**Consultation Response from KC,
Highways Development Management**

2021/91946 Brenntag Uk Ltd, Union Mills, Oxford Road, Gomersal, Cleckheaton, BD19 4JW

Discharge of conditions 4, 5, 6, 7 & 8 on previous permission no. 2019/93797 for erection of extension to existing warehouse and formation of new car park

Date Responded: 10/05/22 Responding Officer: CNB Responding Ref: K9-9SE/7

P21-3278-00-01

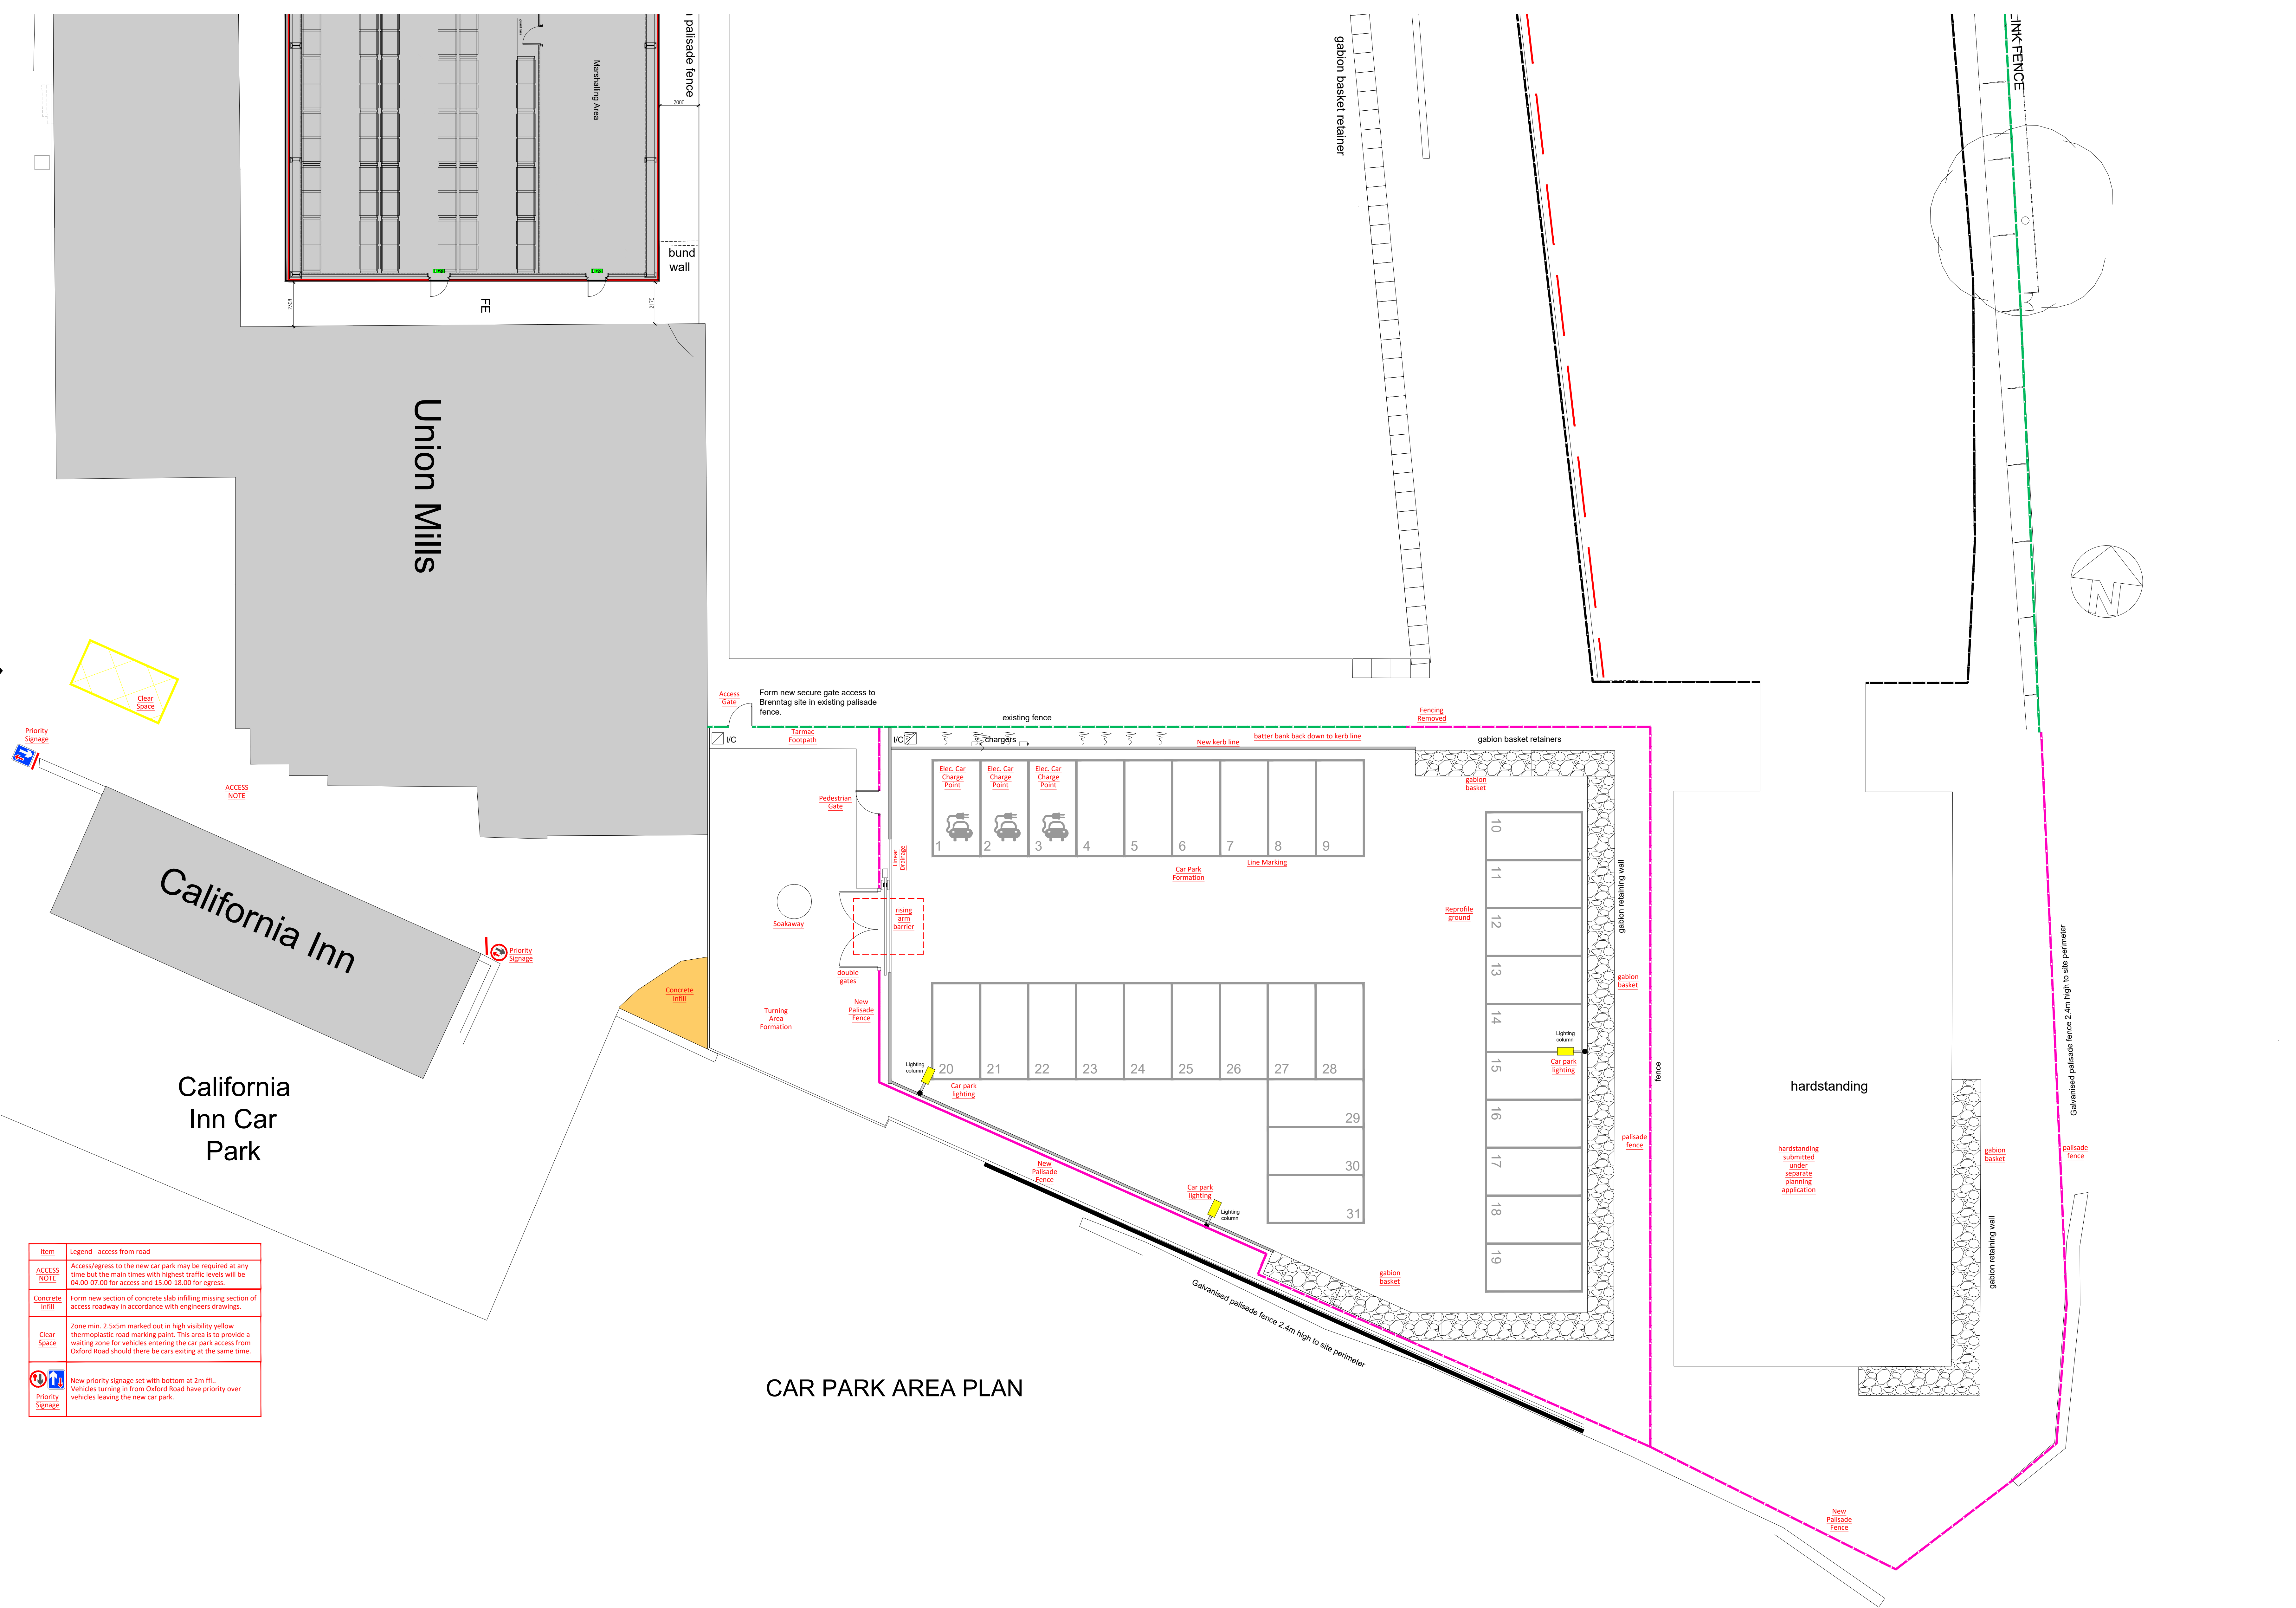
Drawing number P21-3278-00-01rev J clearly shows the turning area marked within the access to the car park which would allow any vehicles not authorised to use the car park to be able to turn and exit the site in forward gear. This is suitable for the discharge of condition 6.
